20140855.1/0902A/R1/BW

**Central Park - Block 4N - Review of Comments**

This letter confirms that an acoustic review of the comments received regarding the Noise Impact Assessment for the project from the City of Sydney Council in their letter (Ref: R/2014/33/A) in response to the Block 4N SSSDA have been conducted by this office.

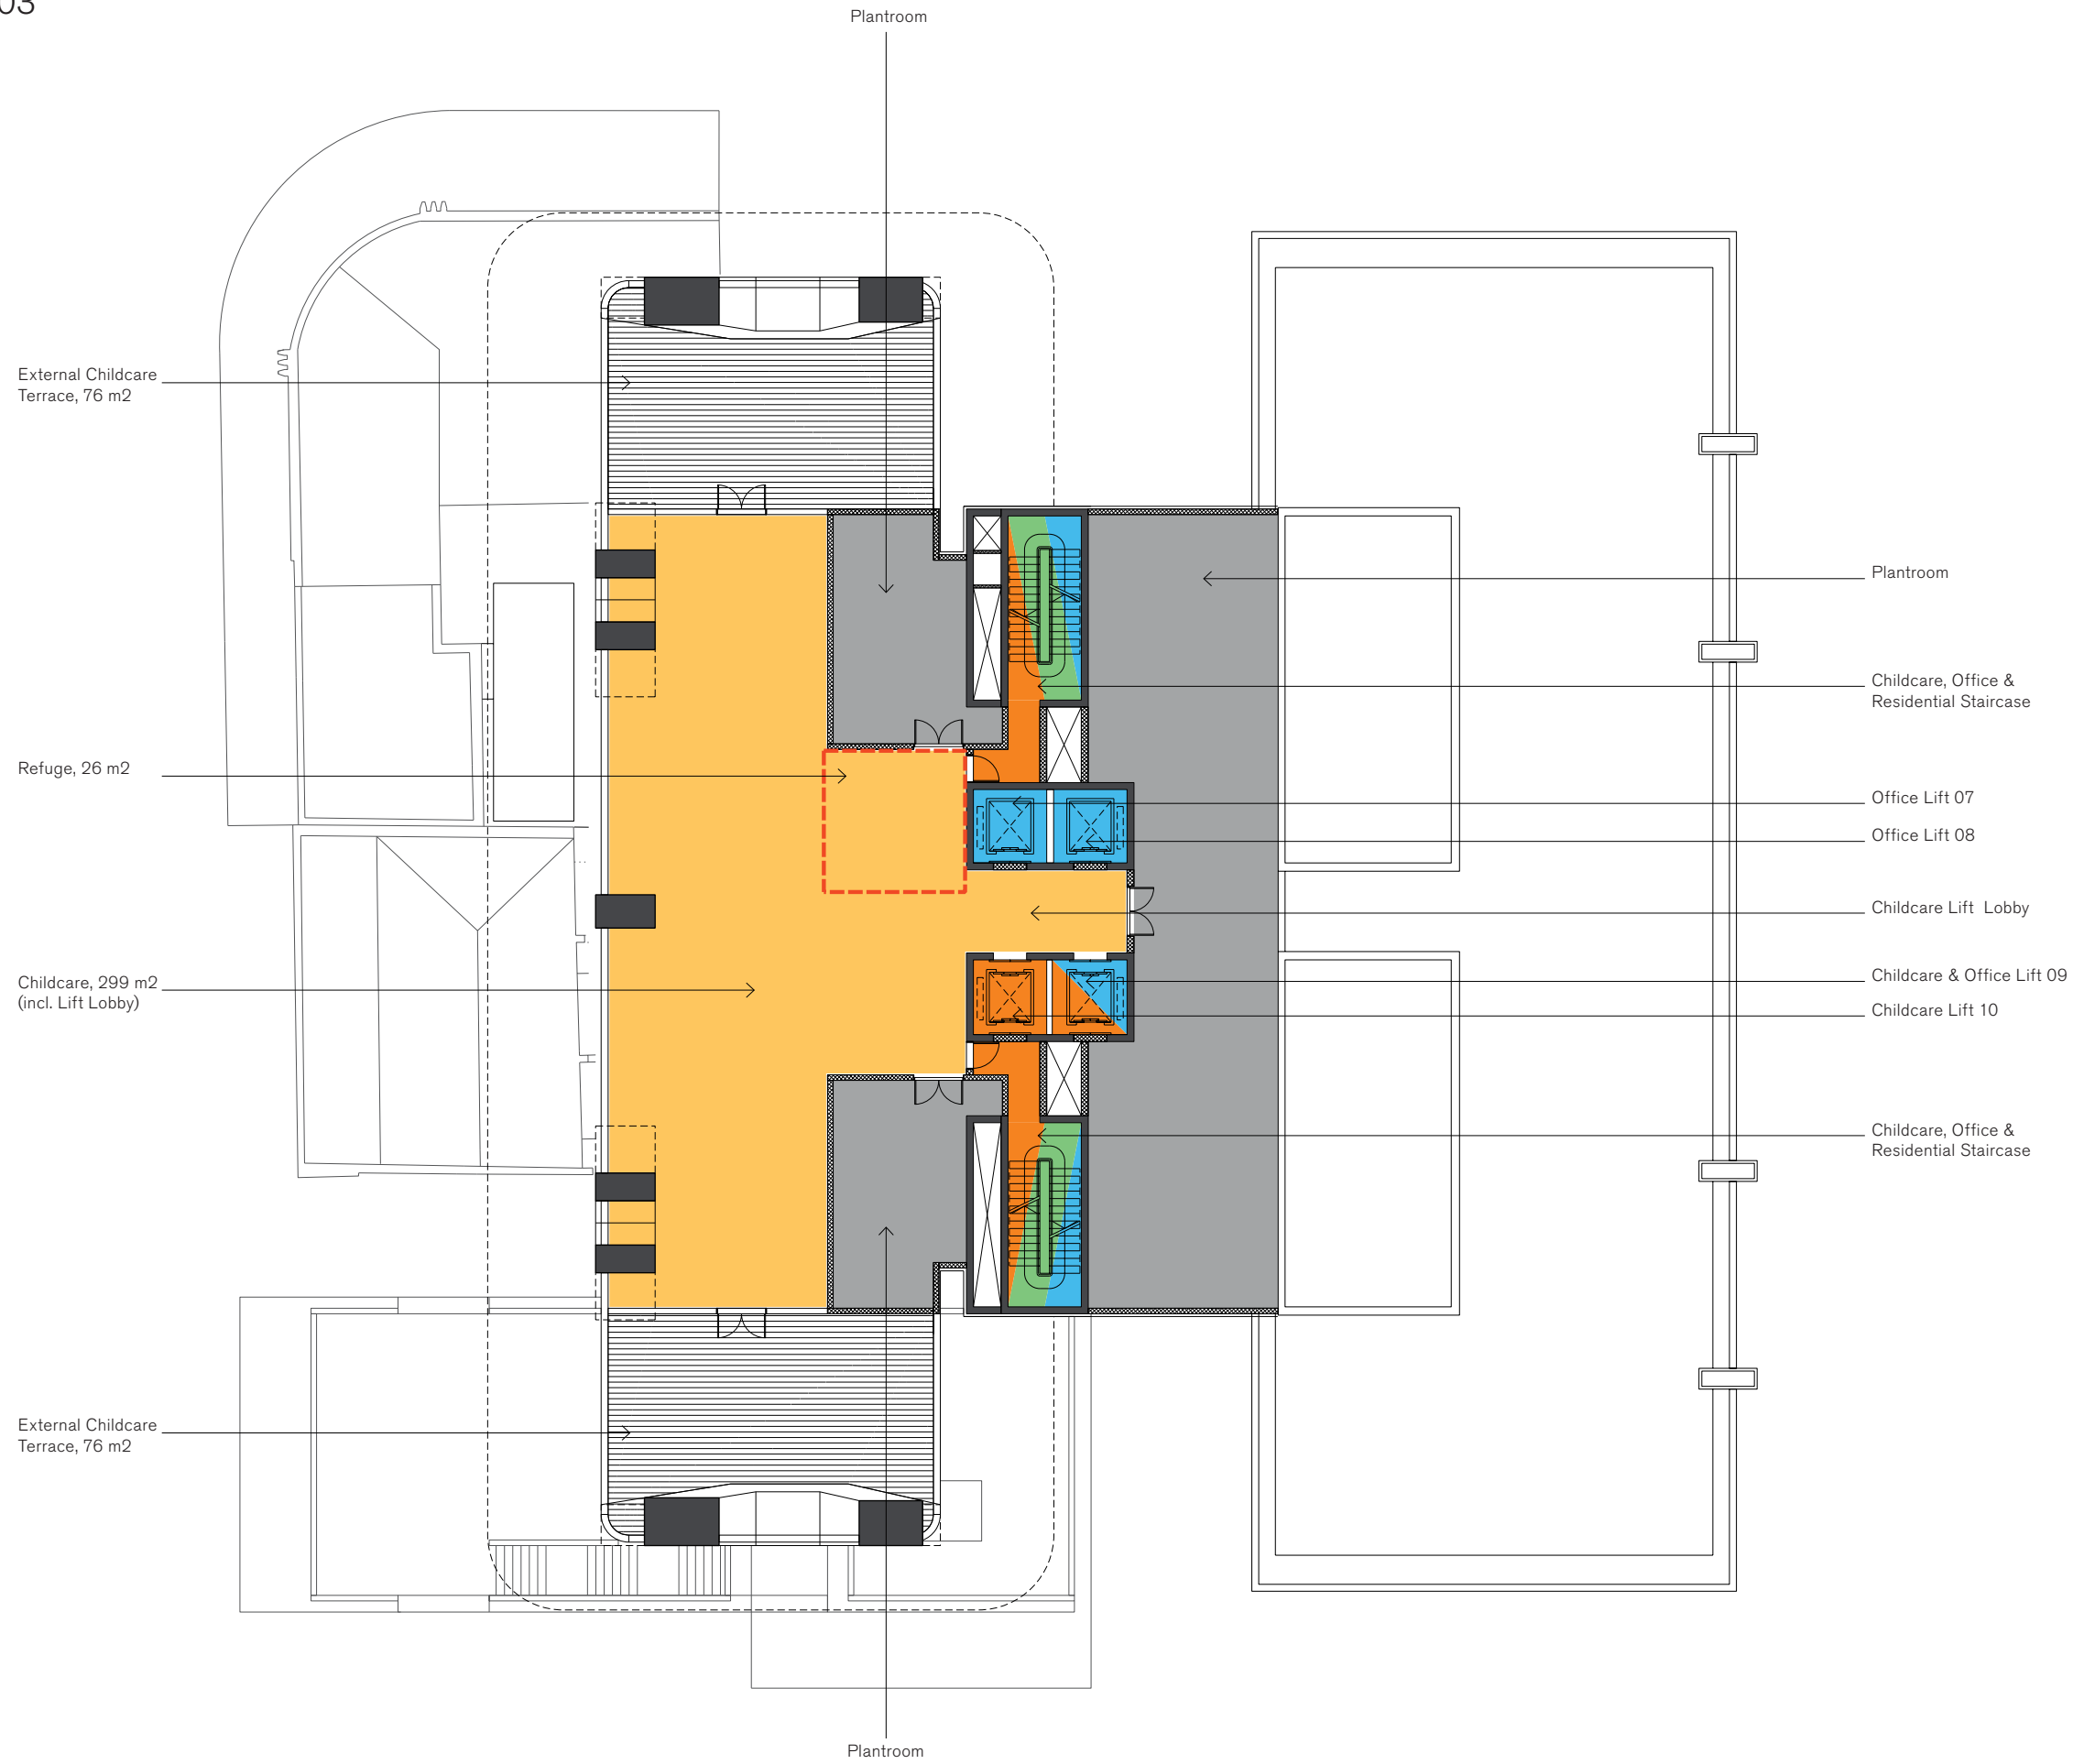
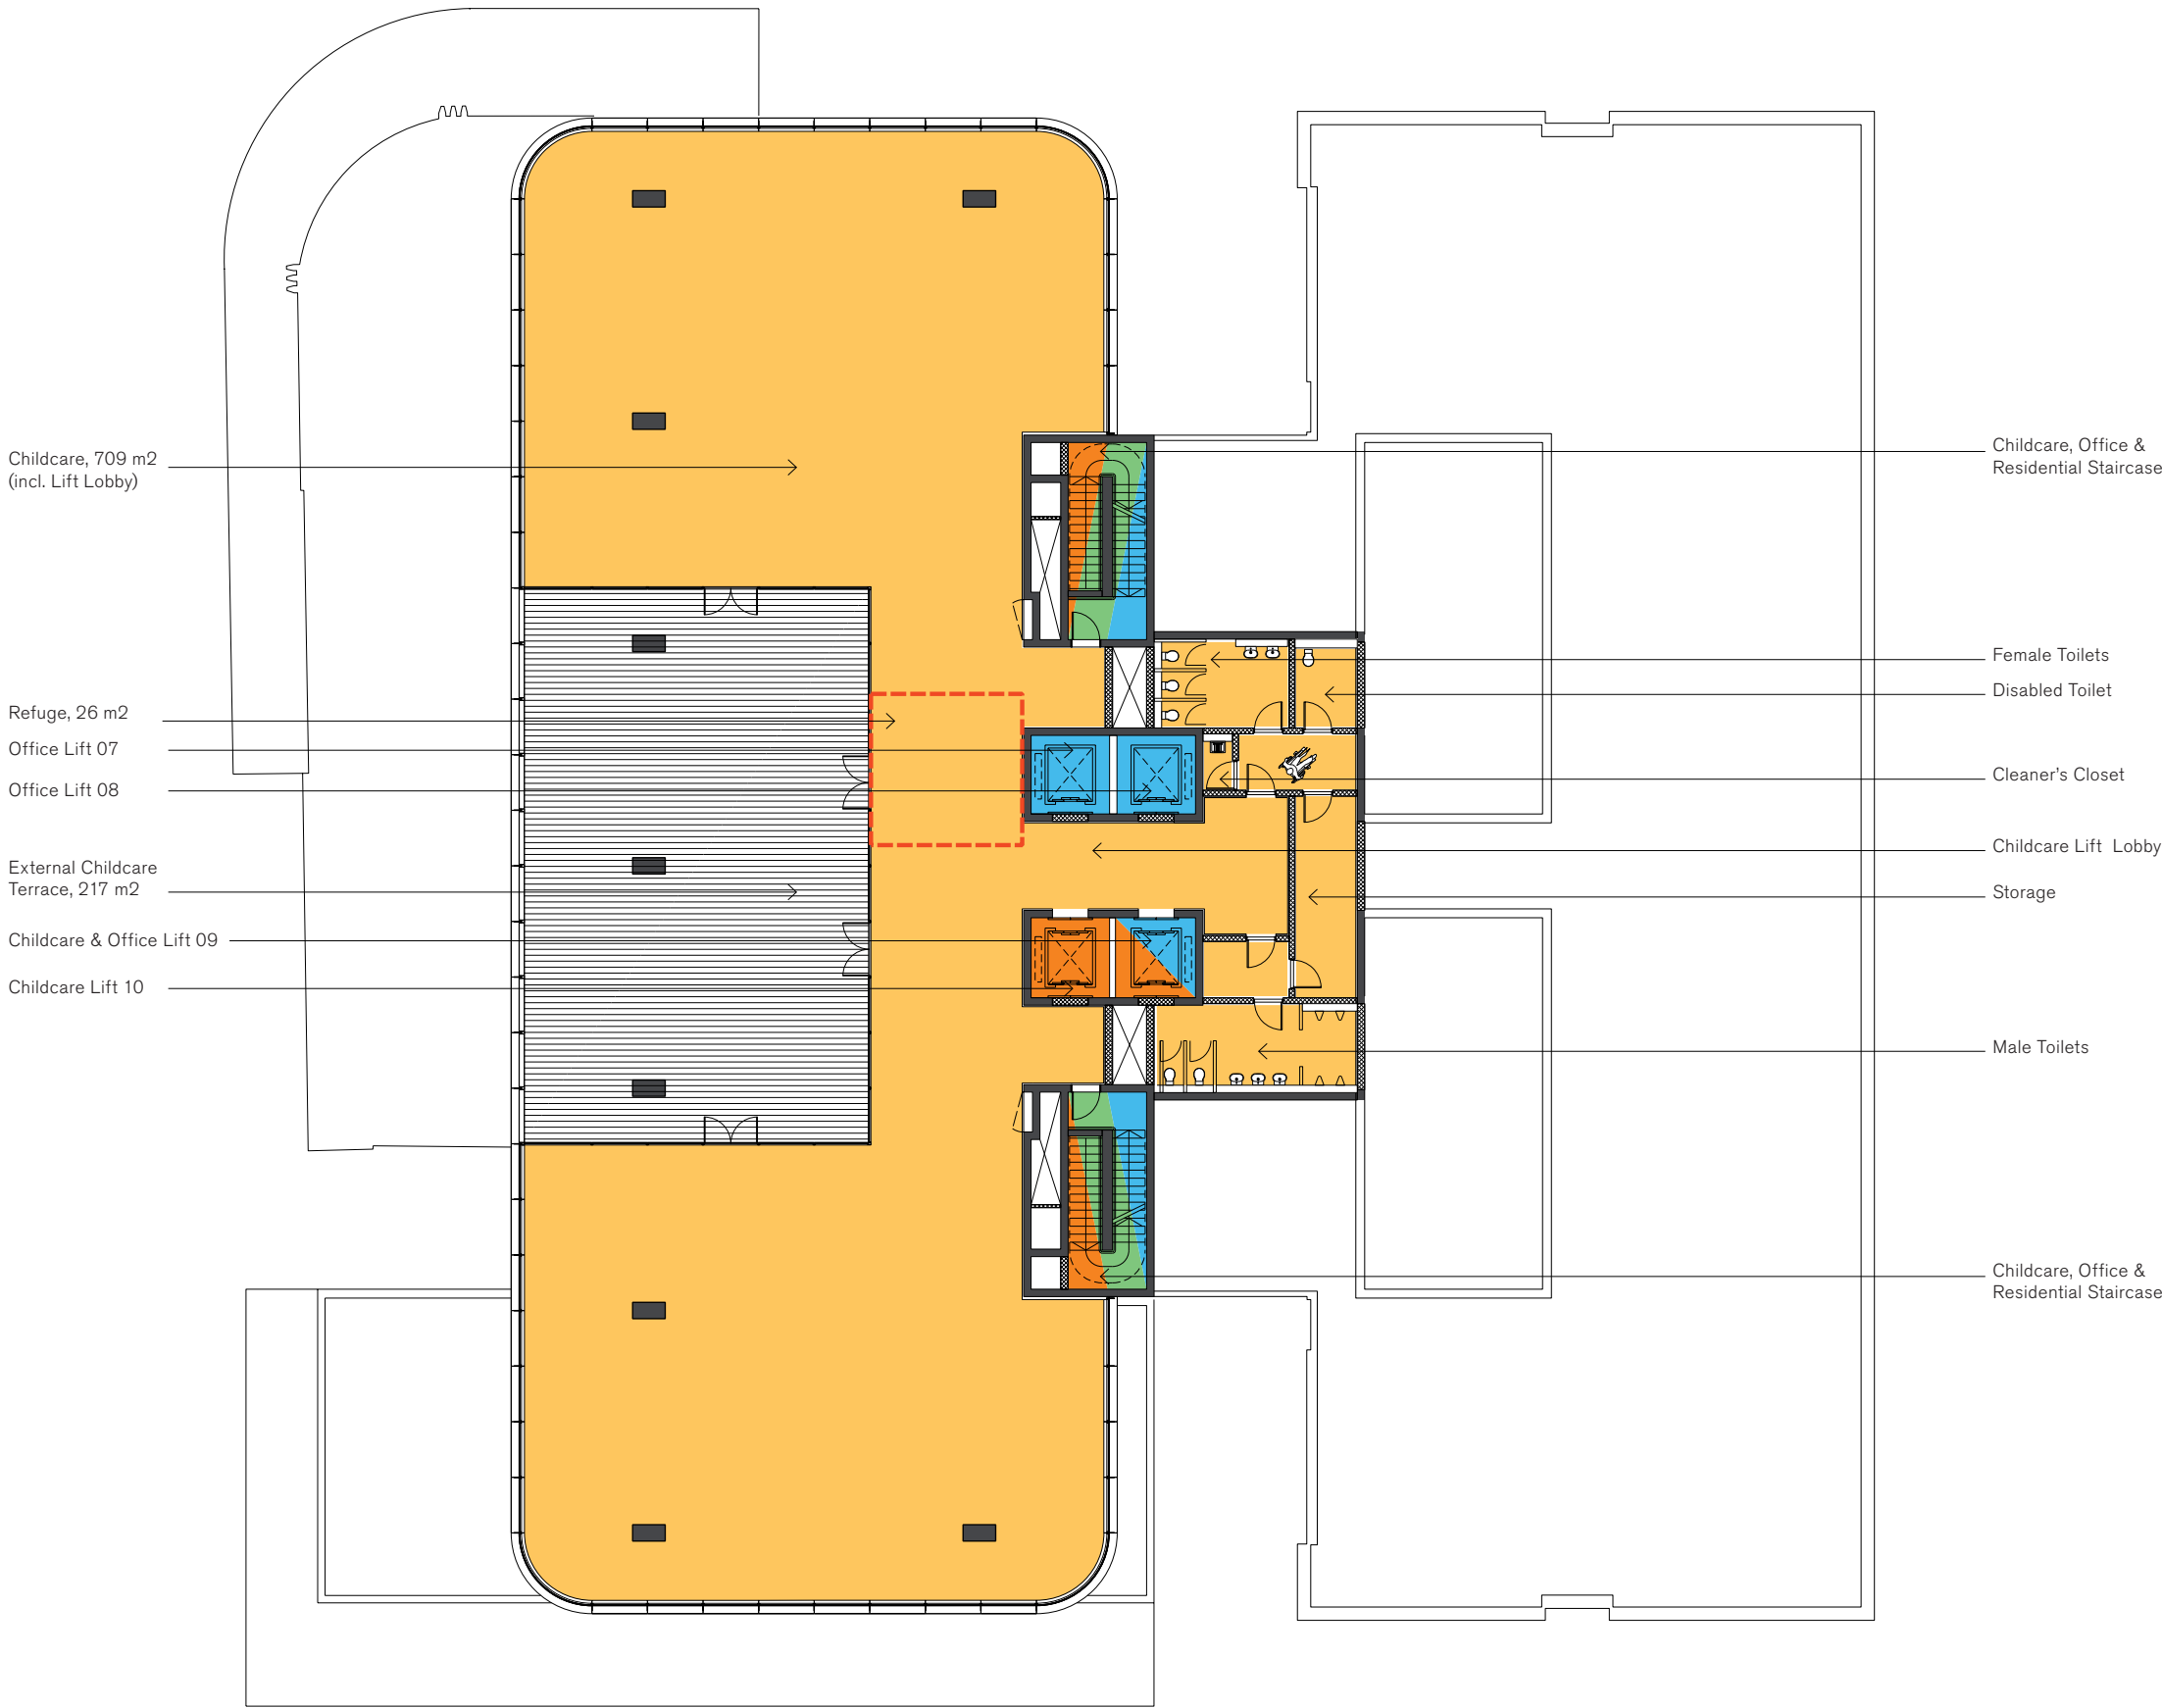
- *Part 6.2.1.1 refers to a total of 90 children within the centre. Specify the maximum number of children in each outdoor play area and consider any noise break out from internal portions of the child care centre;*

The assessment has been undertaken based on the proposed number of children within the centre. The assessment has assumed that generally half the number of children which the centre could be shared within the external areas. That is 45 children using both of the external areas.
